Reference: 25139

Re: 105 Forest Road & 1A Hill Street, Hurstville (SSD-84552728) – Traffic Response to RFI

Response to RFI

GROUND FLOOR

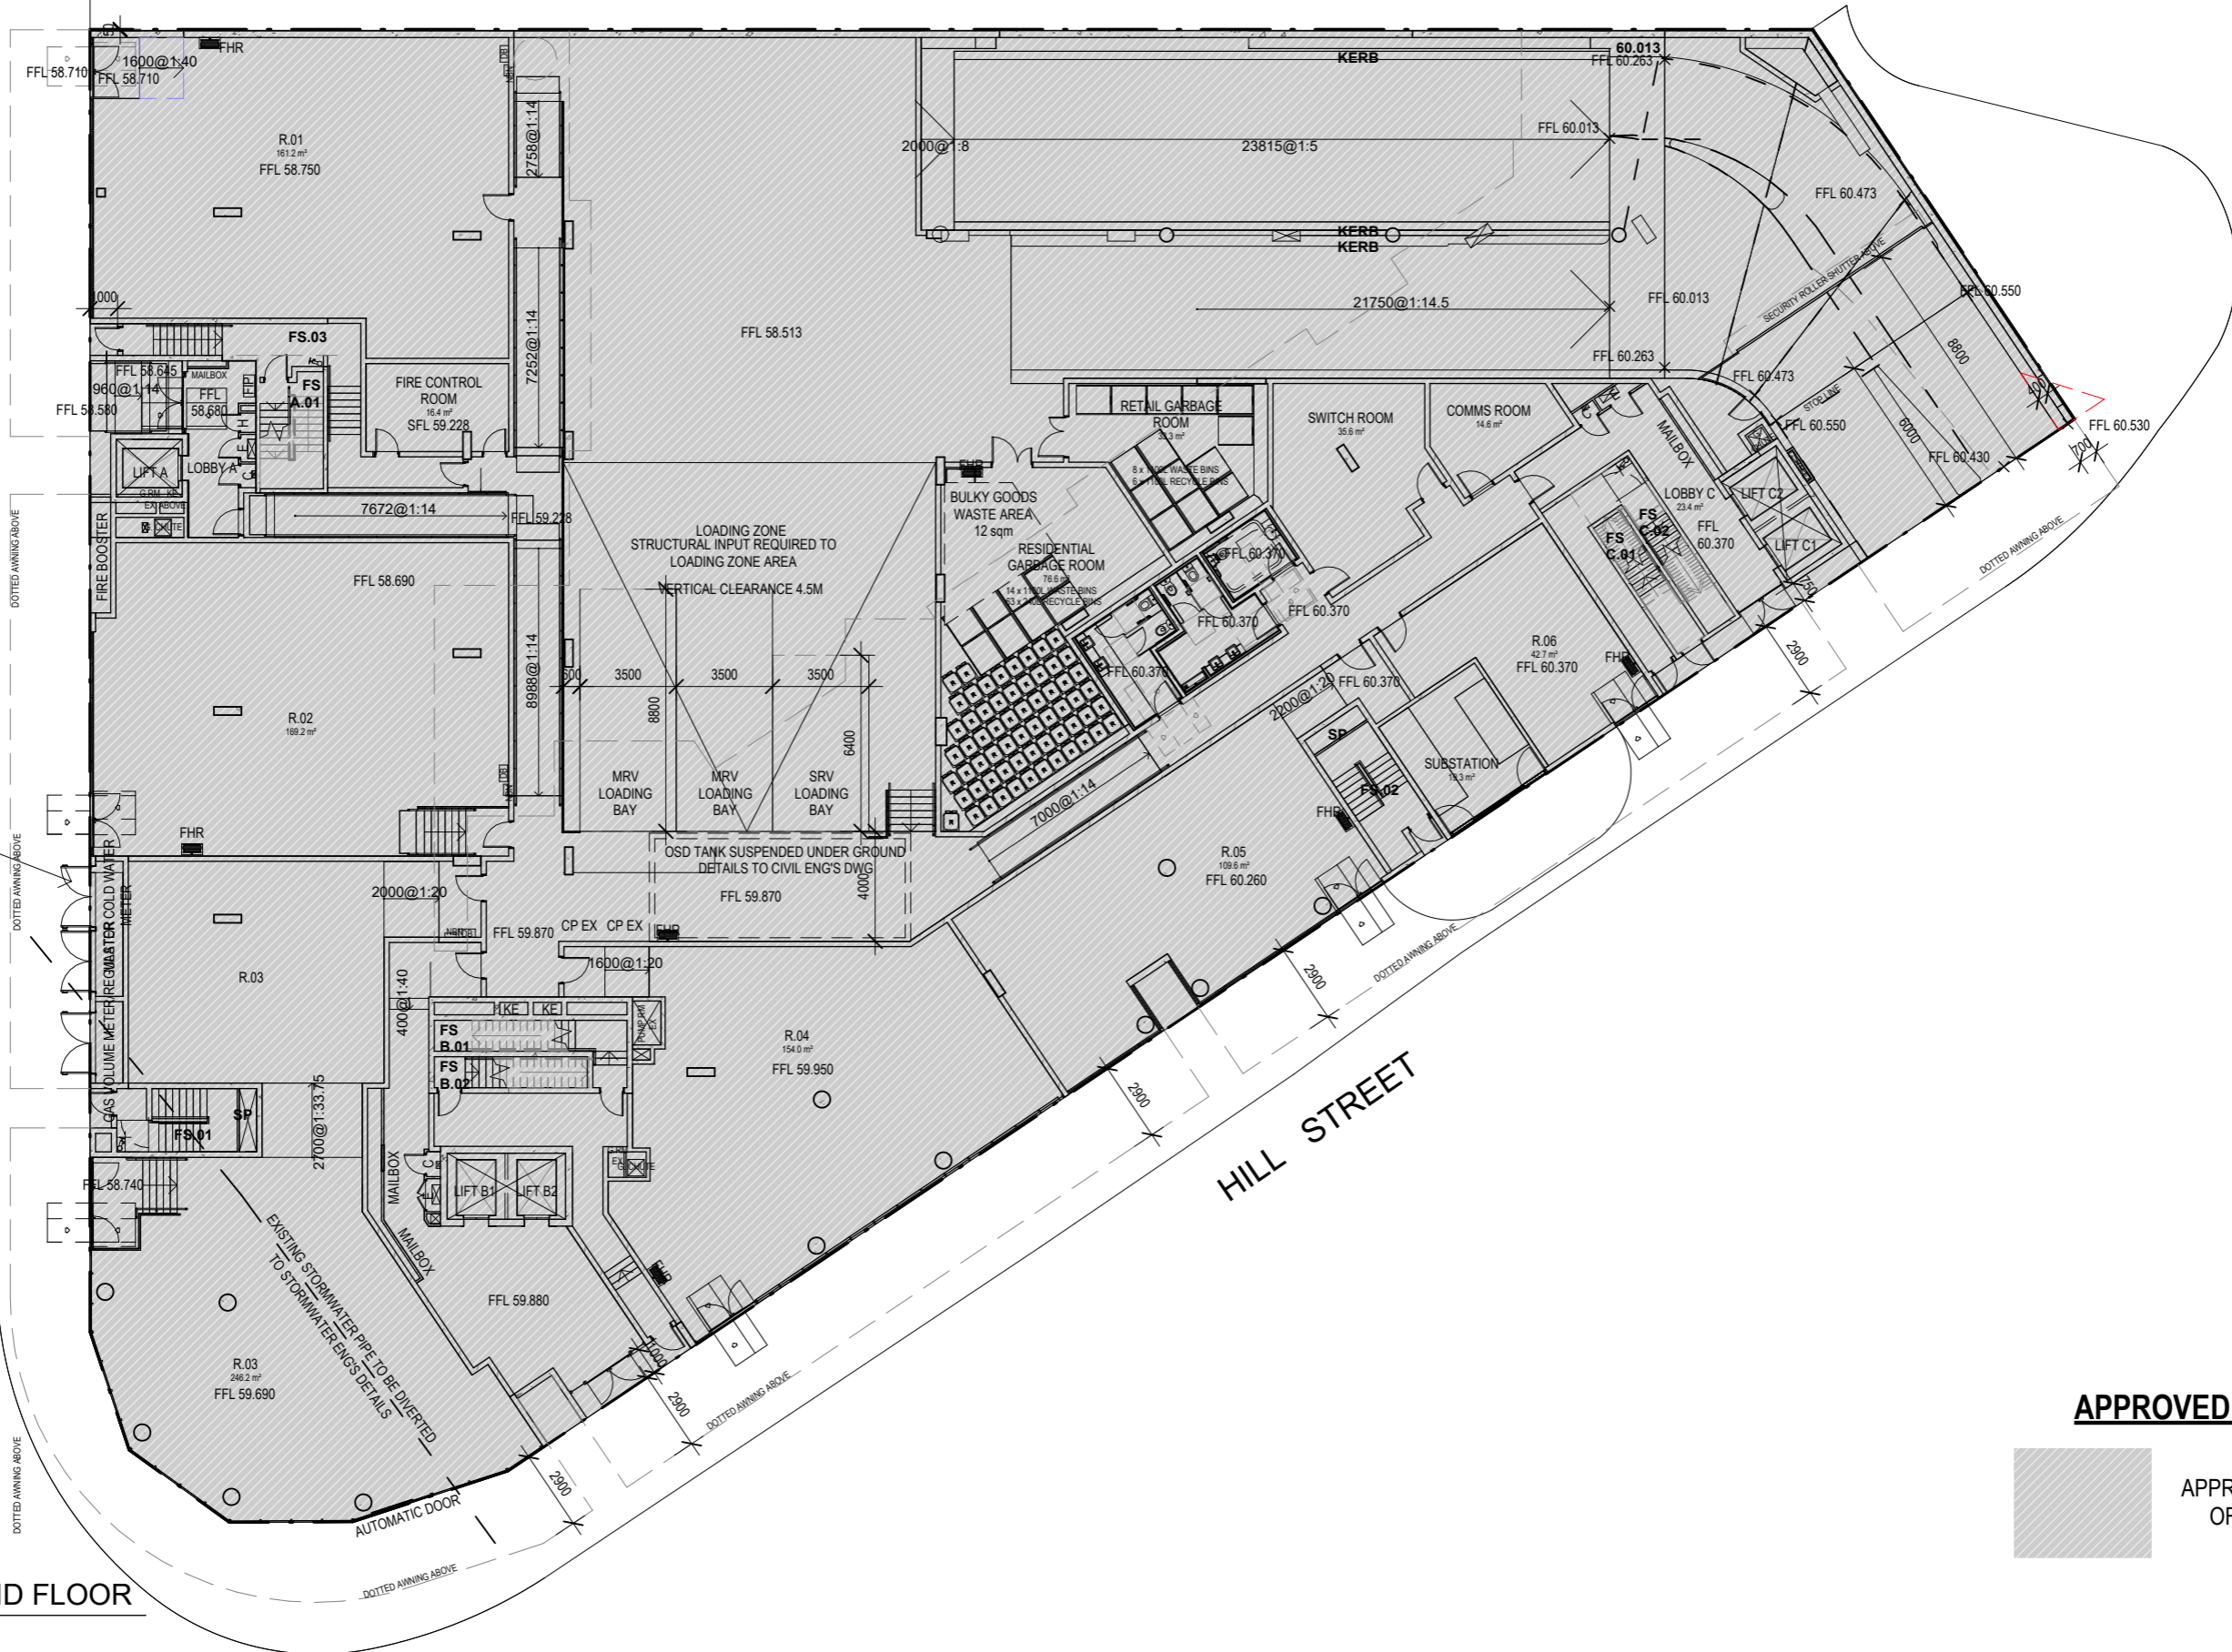
• Excessive Vehicle Crossing Width – the proposed vehicle crossing width of approximately 9m is unsatisfactory on pedestrian safety grounds. It is unsafe for pedestrians on this busy footpath area having to cross such a wide area with vehicles frequently entering and exiting the site, including heavy vehicles. An analysis will need to be carried out to determine if a vehicle crossing is the appropriate facility on pedestrian safety grounds and if the entry and exit sides need to be separated and a refuge type facility provided o Council's footpath area to improve safety.	The 8.4m wide combined access driveway complies with the Category 2 access driveway as per AS2890.1.

• Sightlines for Pedestrian Safety – there is no mention in the TIA, nor can it be reasonably determined from the architectural drawings,	A 3D perspective of the access driveway is provided below for reference, demonstrating compliant pedestrian sight lines.

if sightlines for pedestrian safety at the vehicle crossing satisfy the requirements of AS/NZS 2890.1:2004 Parking Facilities, Part 1 - off street car parking.
